SSD 6917: OAKDALE SOUTH – S.96(1) APPLICATION TO MODIFY CONDITION D16.(E)

I write on behalf of Goodman, the applicant to SSD 6917 (Oakdale South Industrial Estate), to lodge an application under S.96(1) of the Environmental Planning and Assessment Act 1979 (the Act).

OAK MP 13 (J)

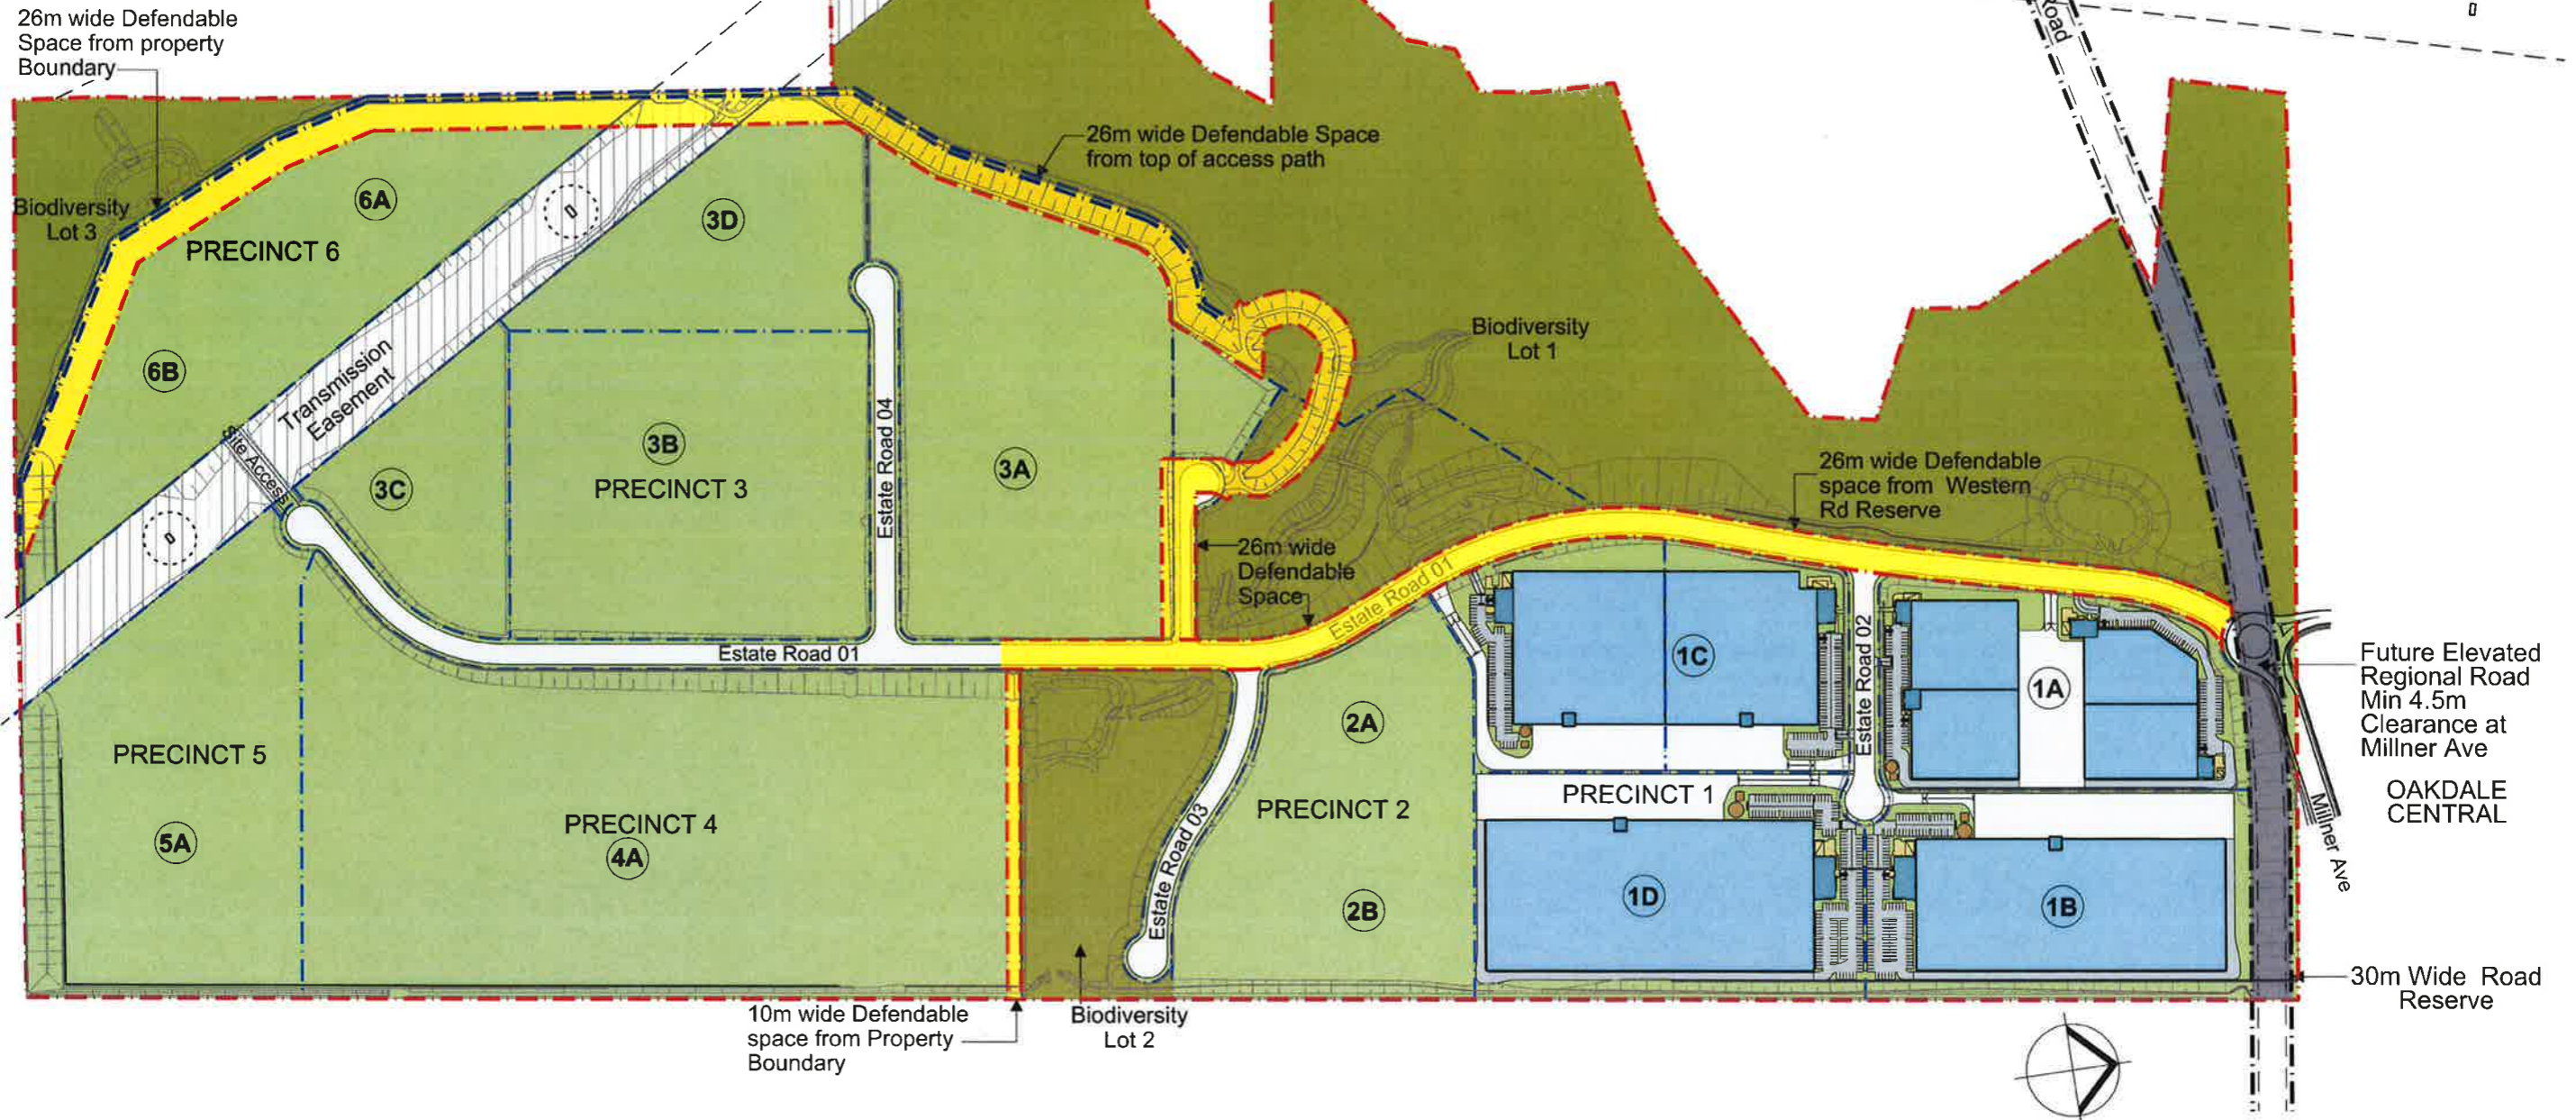
- (e) *a restriction to user for each lot requiring that at the commencement of building works, and in perpetuity, each affected lot shall be managed, in accordance with the drawing OAK MP 13 (C) titled 'Fire Protection Plan', prepared by SBA Architects, dated 4 September 2015, to be endorsed by Fire and Rescue NSW and approved by the Secretary prior to ~~issue of the Construction Certificate for Stage 1~~ commencement of any on-lot building works in Precinct 1, 4 or 5.*

This modification seeks to vary the timing in which to obtain Fire & Rescue NSW (F&RNSW) endorsement and the Secretary's approval of the 'Fire Protection Plan' (FPP), to occur prior to any on-lot building works for Precinct 1, 4 & 5, rather than prior to any Construction Certificate (CC) for Stage 1, as is currently required under Condition D16(e) wording.

Pursuant to Section 96(1) of the Environmental Planning and Assessment Act 1979 (the Act), we hereby seek to amend **Condition D16(e)** of SSD 6917 to require Fire and Rescue NSW endorsement and approval by the Secretary prior to commencement of on-lot building works in Precinct 1, 4 or 5, rather than the Stage 1 Construction Certificate.
